From: MONICA and MARK ROBBINS
To: [Lauren Anderson](#)
Cc: [McIntosh Janet & Dick](#); [Kurt Bulmer](#); [Miriam Bulmer](#)
Subject: File Nos.: CA017-005, DEV17-009, ADU17-003, SHL17-007, SUB17-004--The Lady Bug Trust
Date: Tuesday, May 30, 2017 10:32:54 AM

We have had a chance to do a review of the documents that you forwarded regarding the above noted project located to the north of our property. We have the following comments on this project.

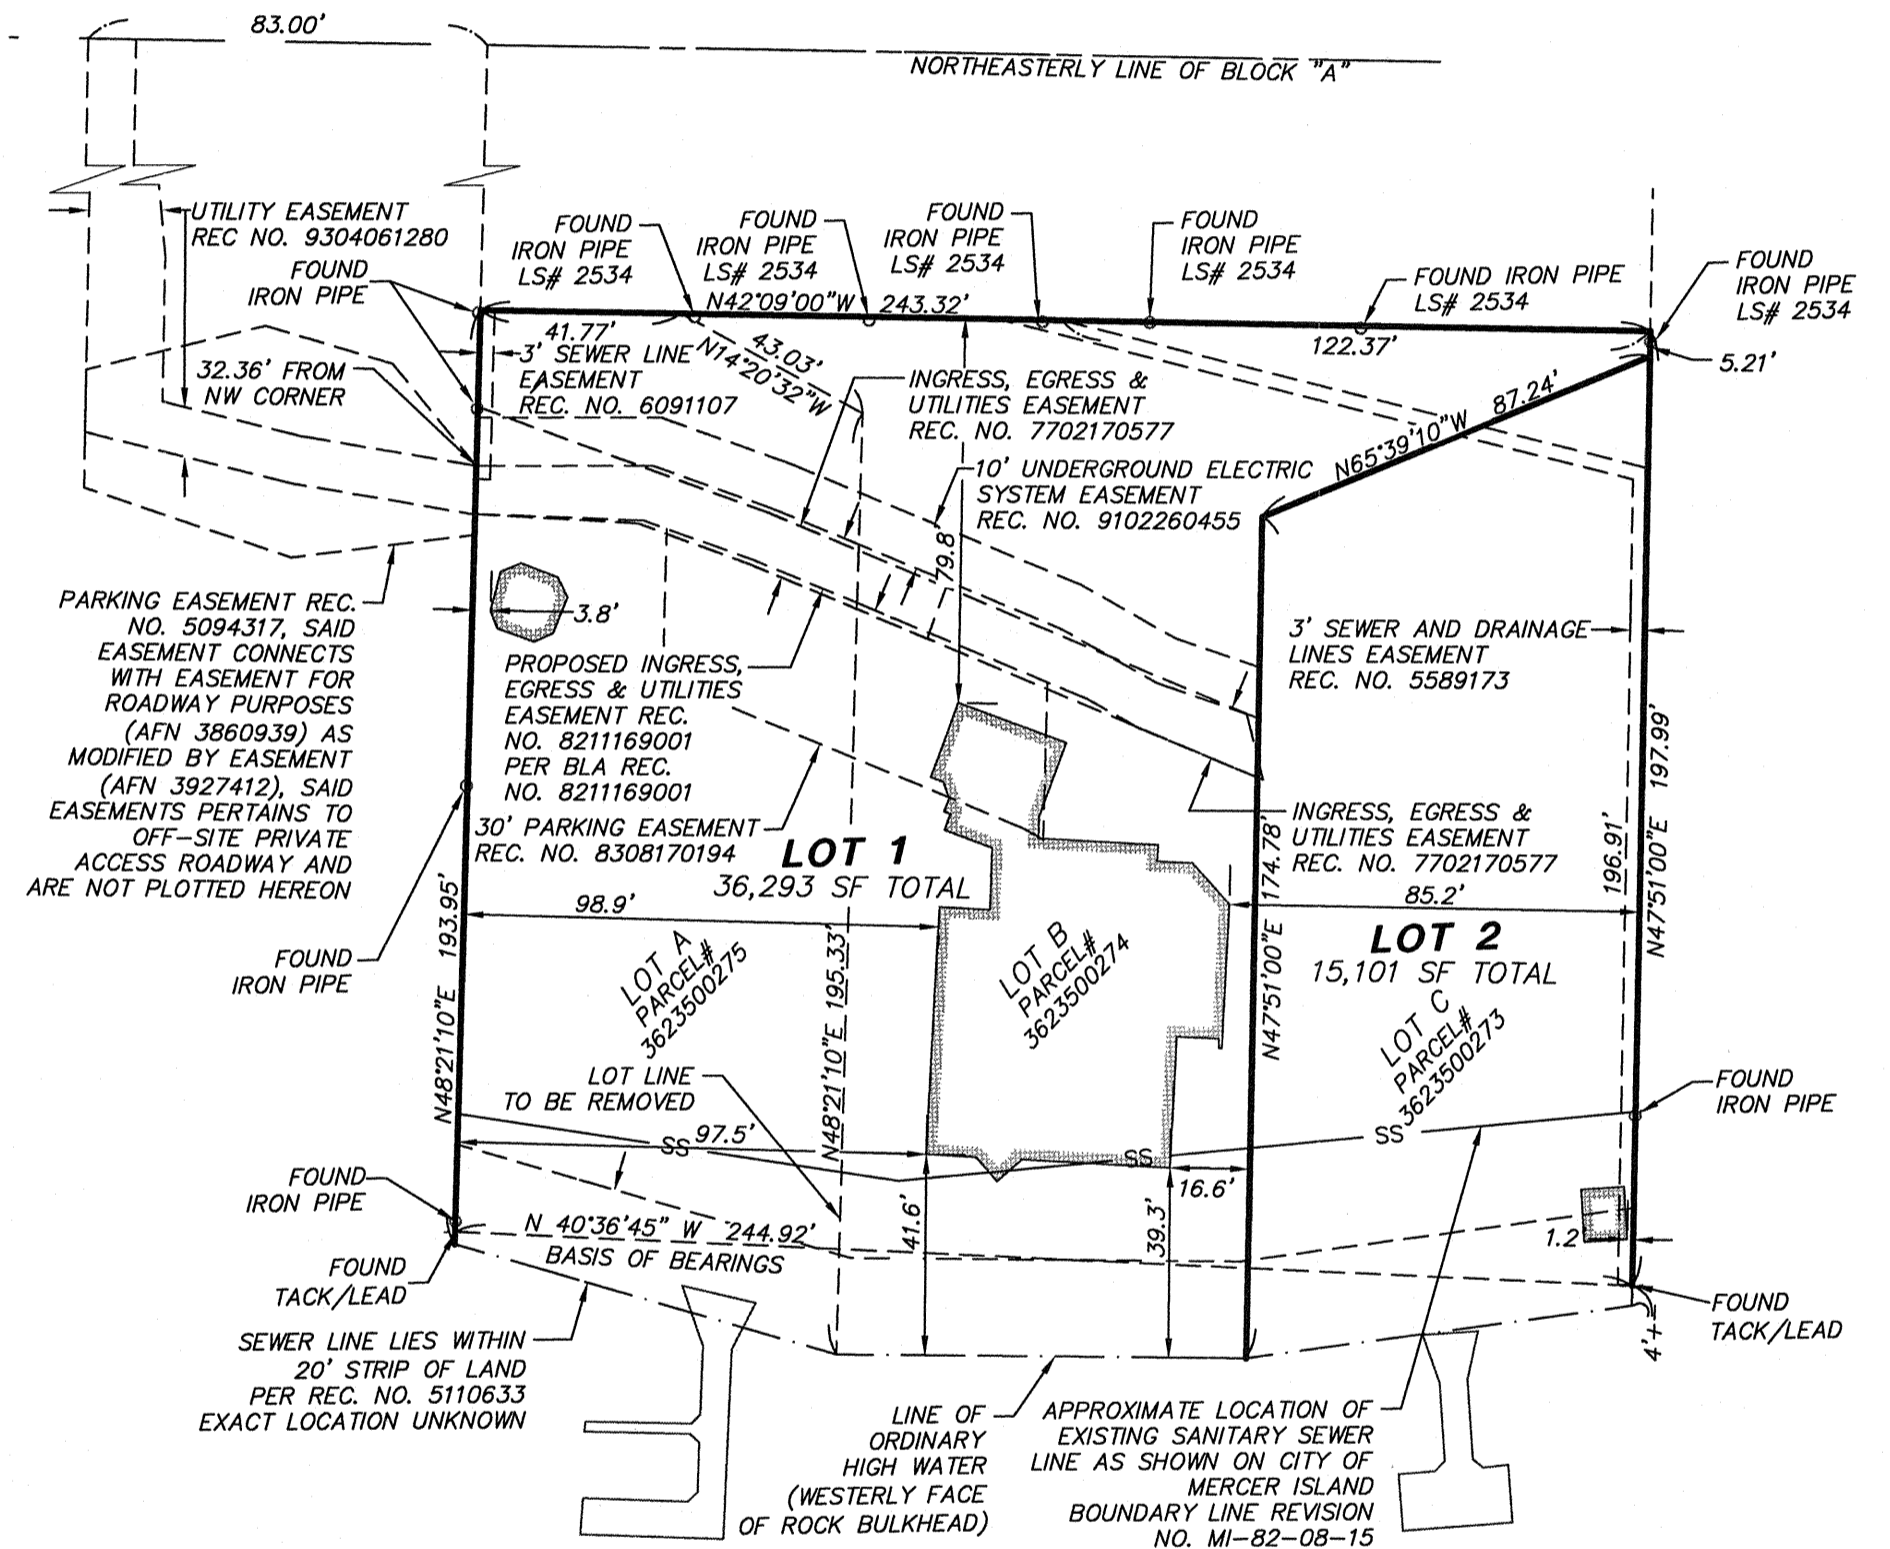
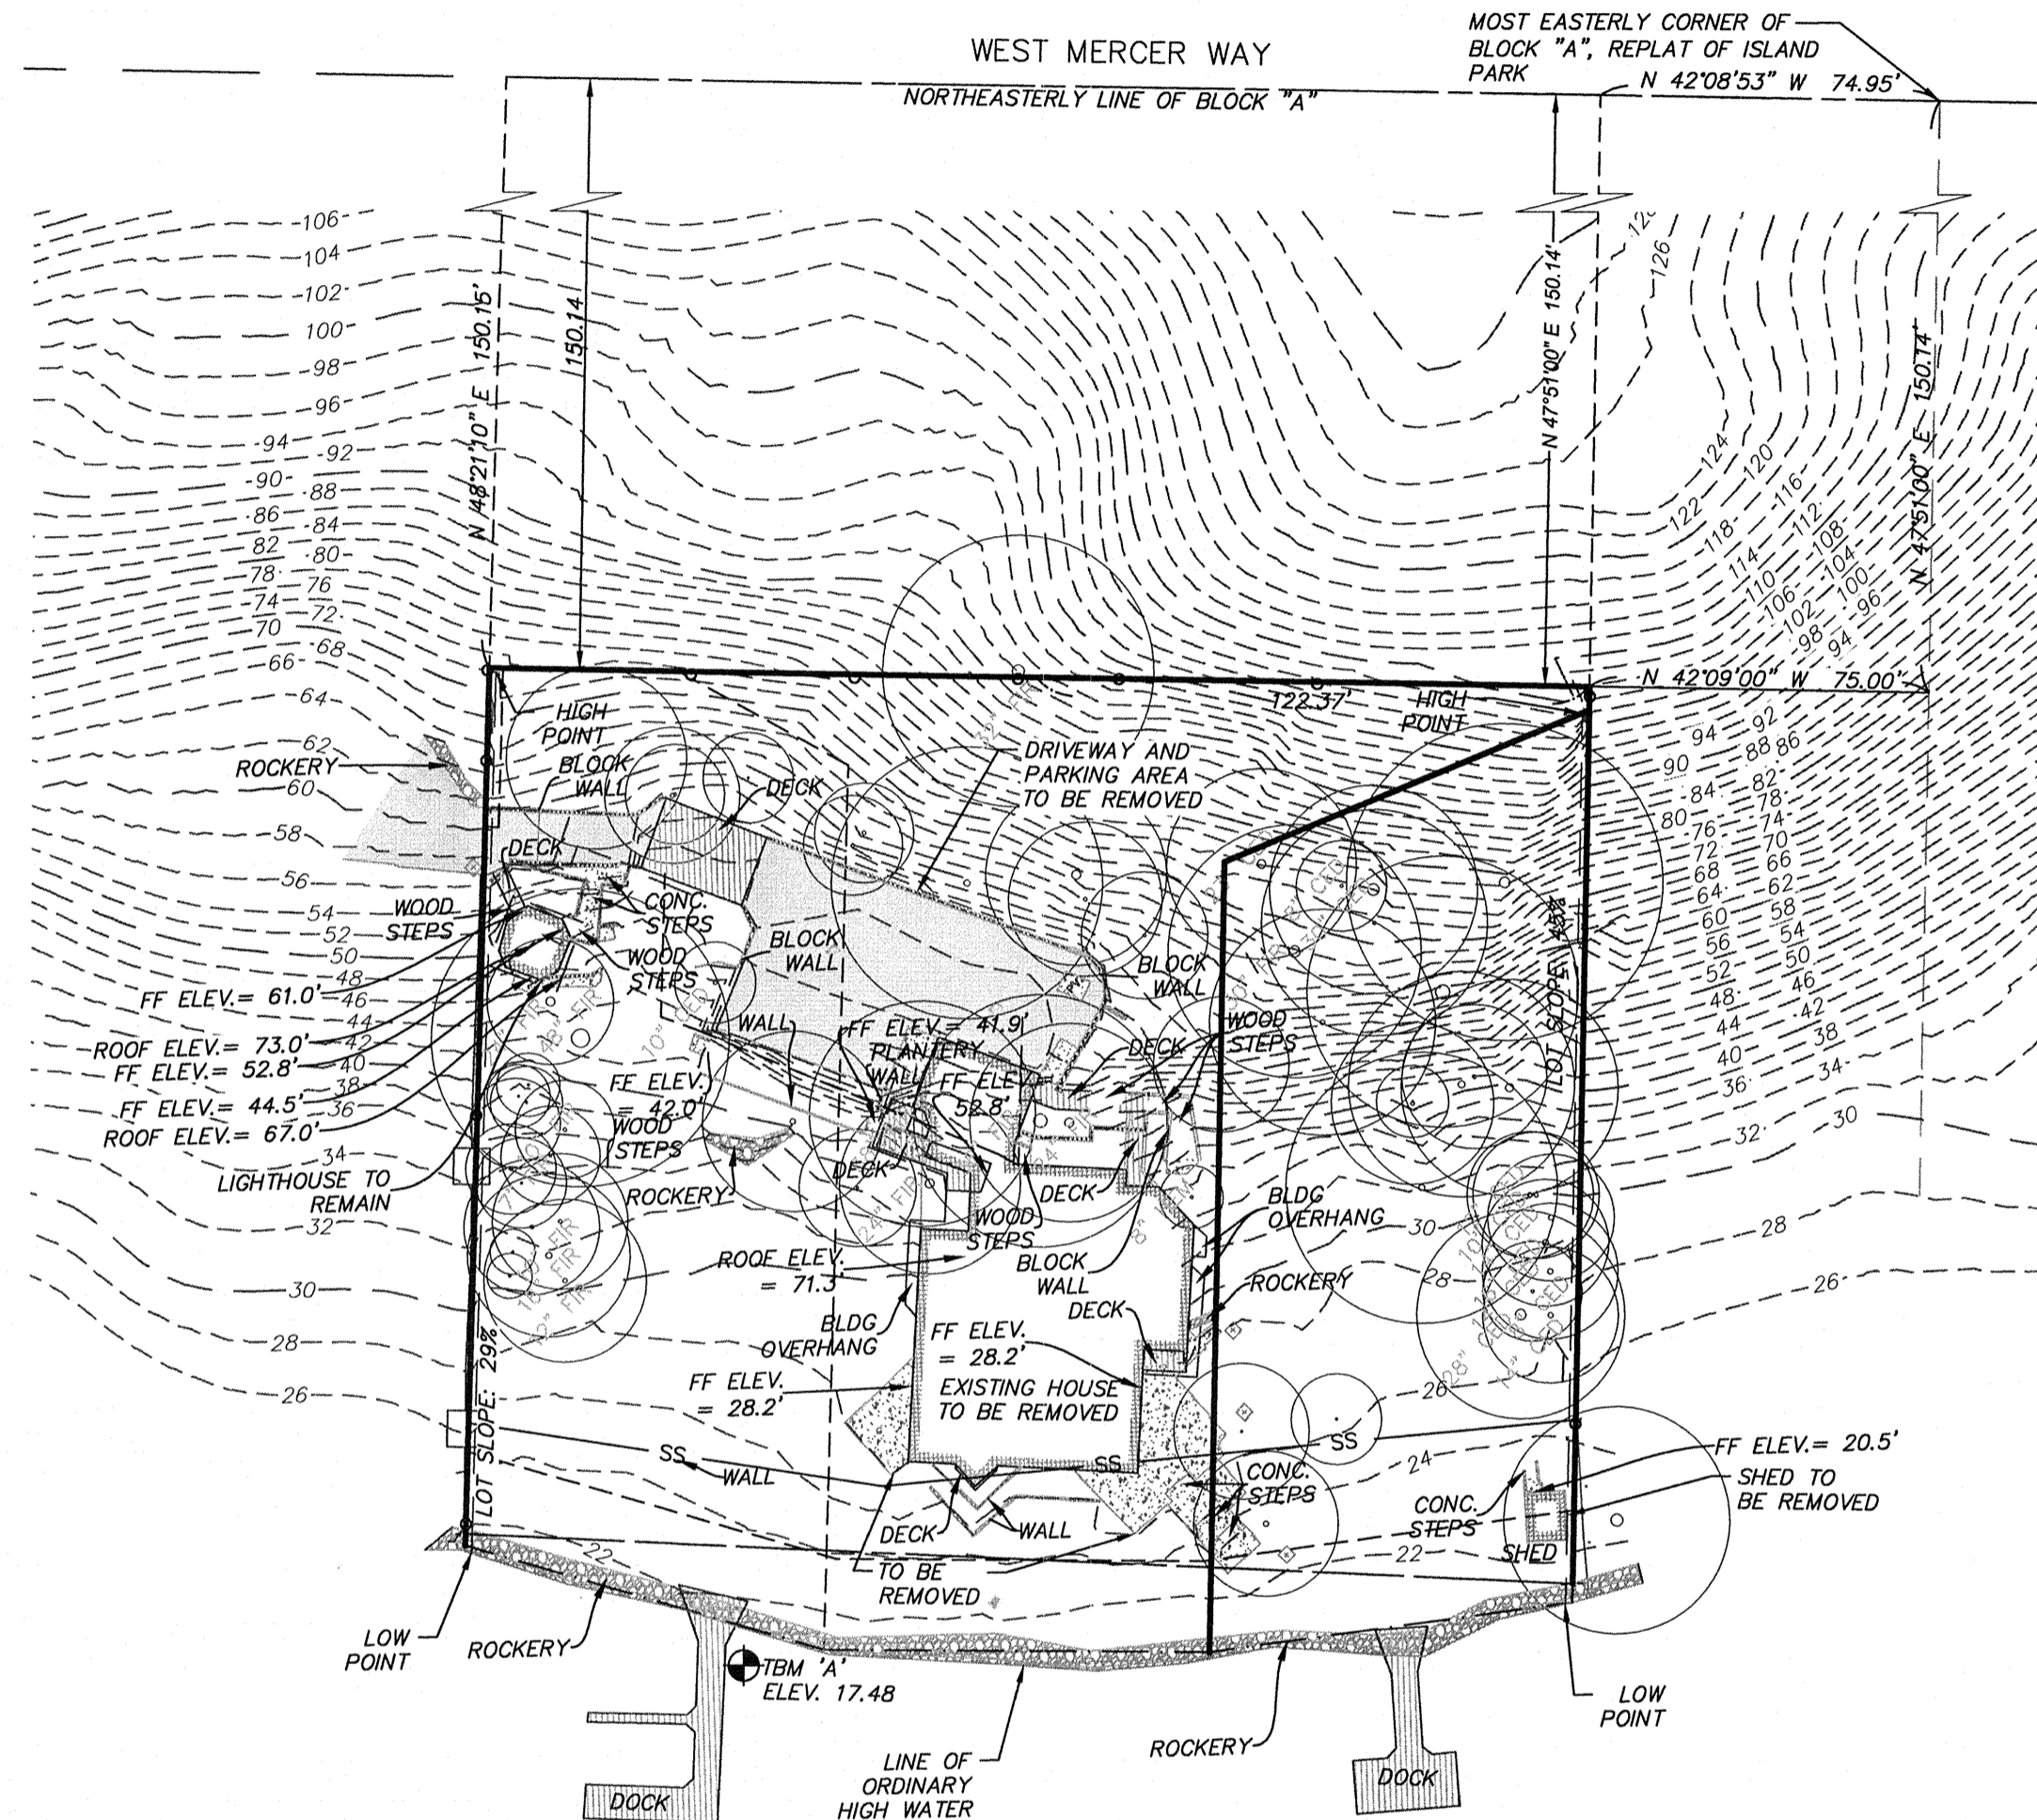
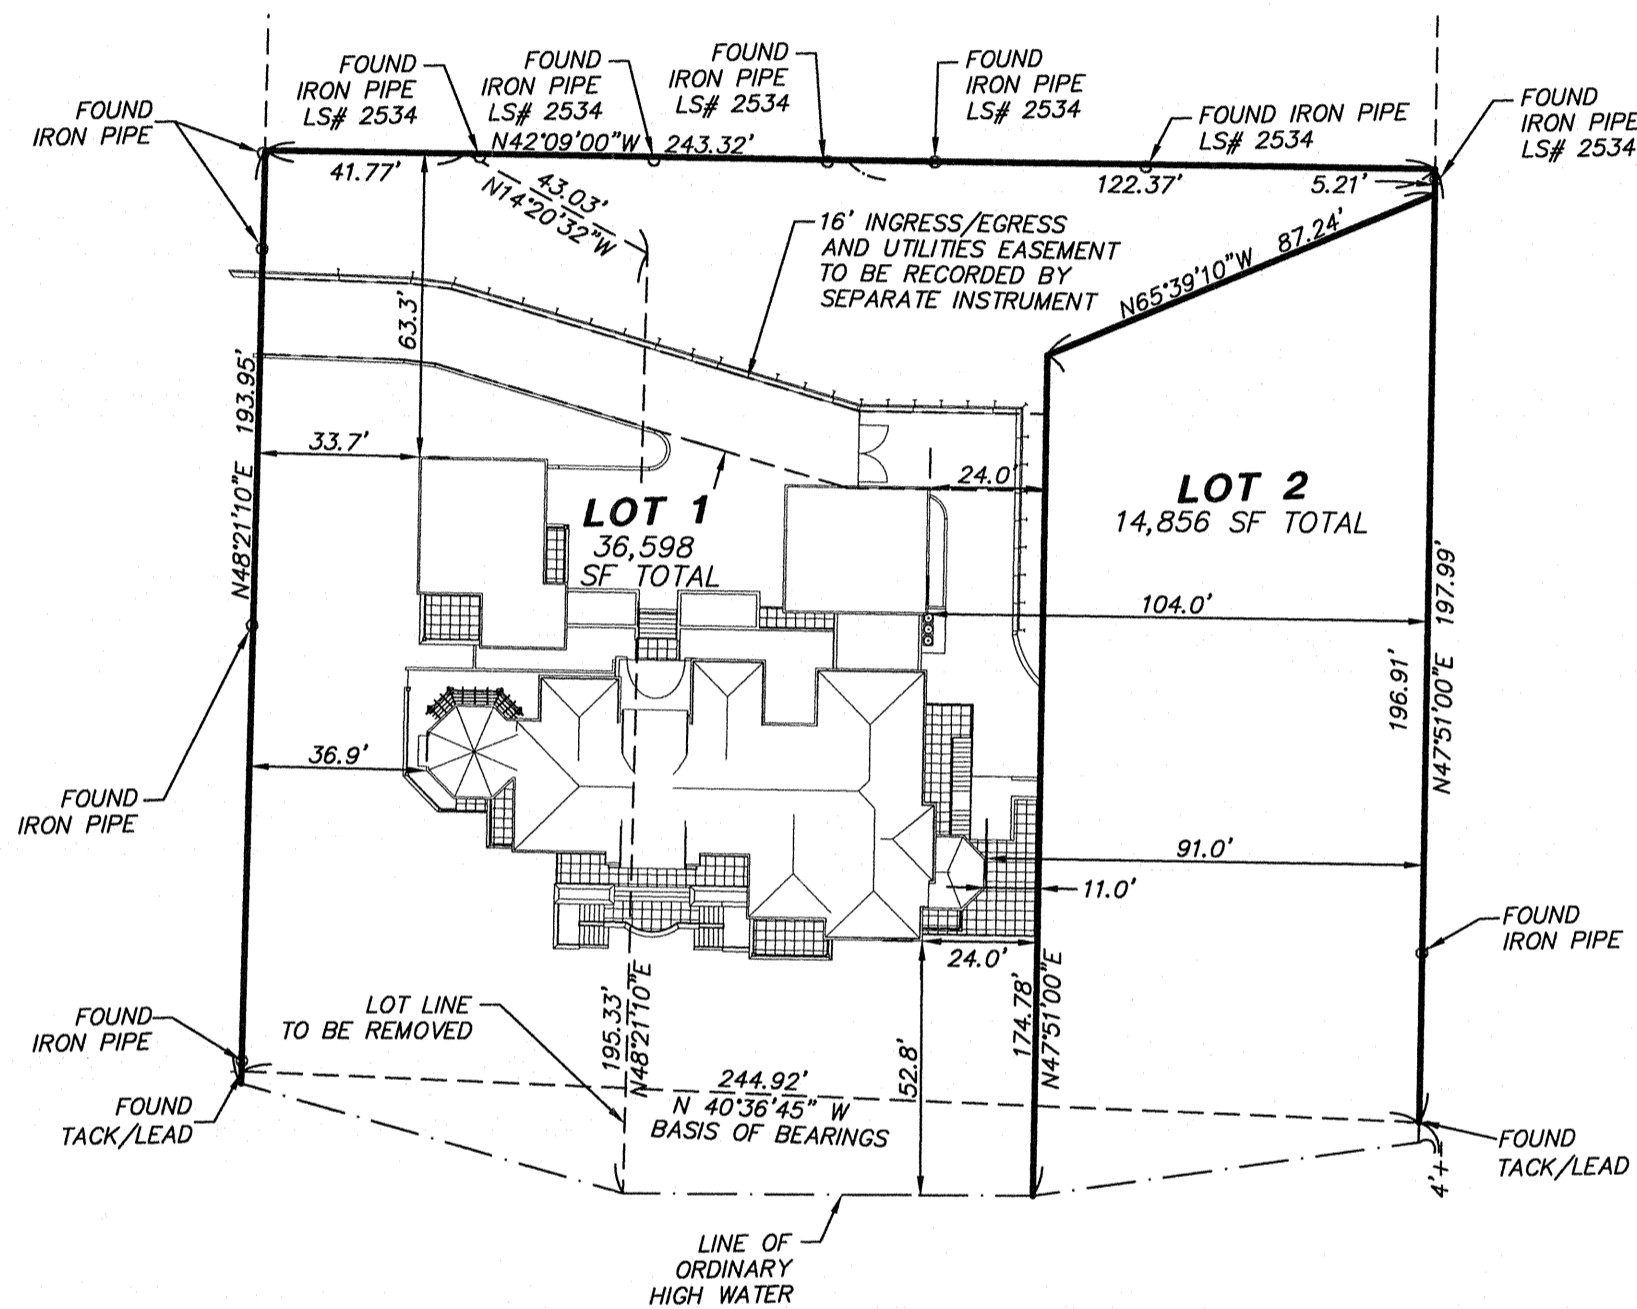
1. We do not think that there is adequate justification offered to grant the Impervious Area Deviation. This is a very large property consisting of two lots that are being consolidated with the lot line consolidation request. The owner will have 36,598 sf of property on which to construct a very large dwelling unit with two garages and an ADU. The evidence that there is adequate area available for development is that there is an 8290 sf existing house (according to tax assessor records) plus garages (all of which are proposed to be demolished). The statement in the application by the "owner" (Michael E. Morgan, Trustee) that "The proposal seeks to build, where feasible, on areas of the site already disturbed by existing development (driveways and structures)." is contradicted by the site plan included in the application that shows the outline of the existing house with garages and paved areas is smaller in footprint than the proposed new residence with associated structures and paved areas and by the calculations in the application. According to the applicant's calculations, the existing impervious area is 28%, well below the normal code allowance. The calculations for the proposed project show 32% impervious area and the application requests 35% impervious area (the maximum allowable by code if an Impervious Area Deviation is granted by the City). There does not appear to be sufficient justification to grant a deviation from the maximum of 30% allowable by code, which was set for good reason. It appears that the only reason that the "owner" is requesting this deviation is to maximize the size of the mega house and associated structures (currently proposed at 12,581 sf!).

2. Consideration of the third lot of the parcel (southernmost) as justification for the Impervious Area Deviation should not be allowed. As proposed, the "owner" is proposing to consolidate only the northernmost two lots, preserving the third (southernmost) lot for future development (more impervious area) and allowing for two rather than one dock on the property.
